Your ref: 3/2018/1121

Date: 27th February 2019

Planning Application 3/2018/1121: Change of use to new restaurant on ground floor and new retail unit at first floor. General refurbishment of existing building with new single storey extensions and structures to courtyard area and to rear elevation. New wall, gate and timber screen to front and side boundaries. Resubmission of application 3/2018/00530. The Stables, rear of King Street, Whalley BB7 9SP

Proposed Courtyard Elevation
Scale 1:100

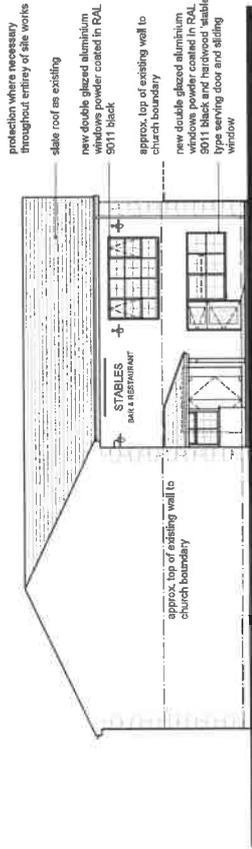
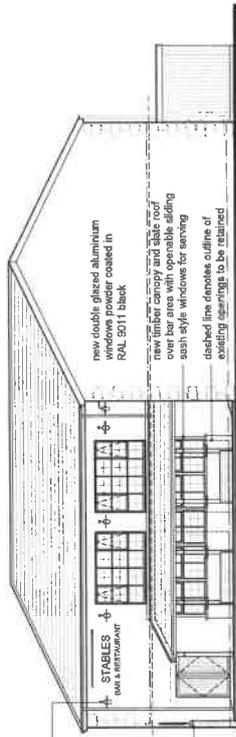
A small section of the existing courtyard entrance is to be closed up with a new blockwork wall, and the front courtyard wall itself is to be topped with a new timber screen, stated to be '*on top of steel channel independent of existing stone wall*' (Plan 3357/13). The new wall section will require foundations, as will the small timber store to the west face and the bar extension to the north face. These works are relatively small in scale and are likely to be in areas already partly disturbed by the construction and reconstruction of the present building. As such it would not appear that these works on their own would justify any archaeological response. If, however, the screens and/or courtyard cover works also require footings to be constructed, then a formal archaeological watching brief may be justified, so that any remains disturbed can be recorded. If this is likely to be the case a standard 'programme of archaeological works' (note: not a 'building recording' condition) condition could be applied to any consent granted, to ensure that a watching brief is undertaken.

Proposed Ground Floor Plan
Scale 1:100

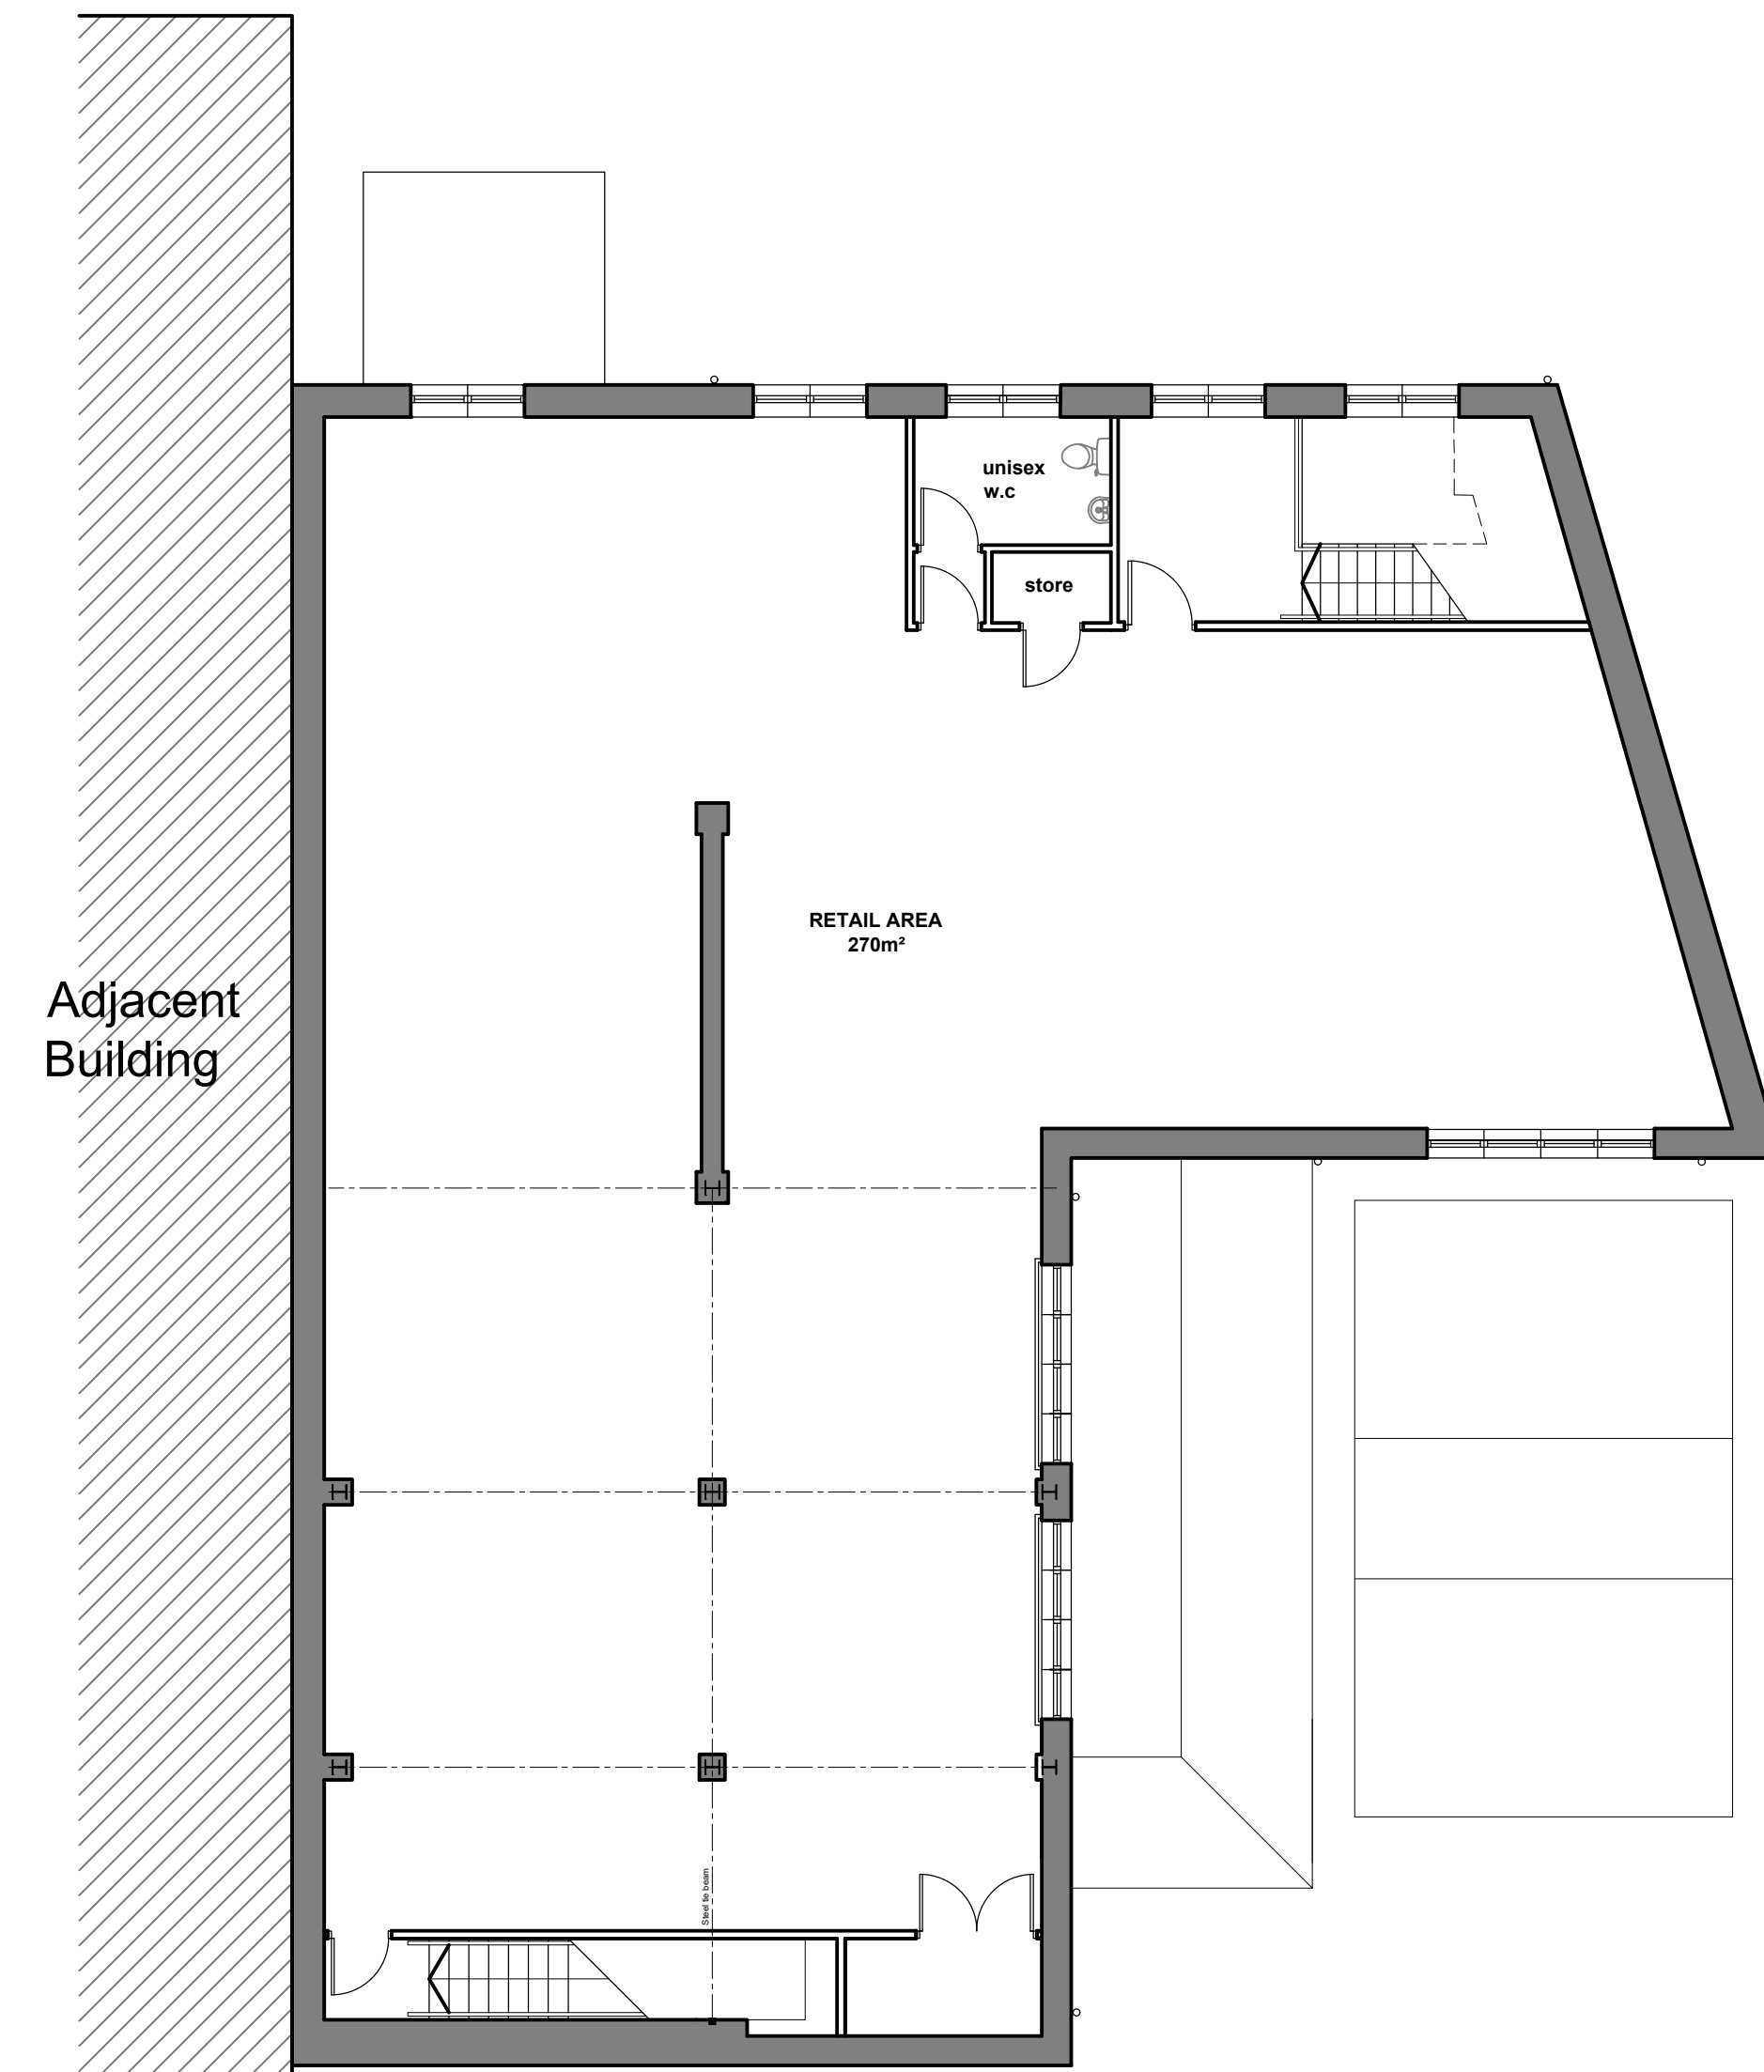
None of the supplied documents give any detail of the 'covered exterior dining area' beyond a simple dashed outline on the Proposed Ground Floor Plan, nor are there any details of the 'timber slatted screens' to be placed alongside the wall to the churchyard boundary, although it is stated that they will be independent of the wall and 'entirely self-supporting' (Plan 3357/13). It is not clear from this if the 'cover' for the dining area and these screens will require foundations or will stand on the extant courtyard surface, although some ground works could be assumed from the statement that "...*any visible roots [to the tree overhanging from the churchyard] will be protected...*" (Heritage Statement p.3). It is thus not possible to comment on their potential archaeological impact.
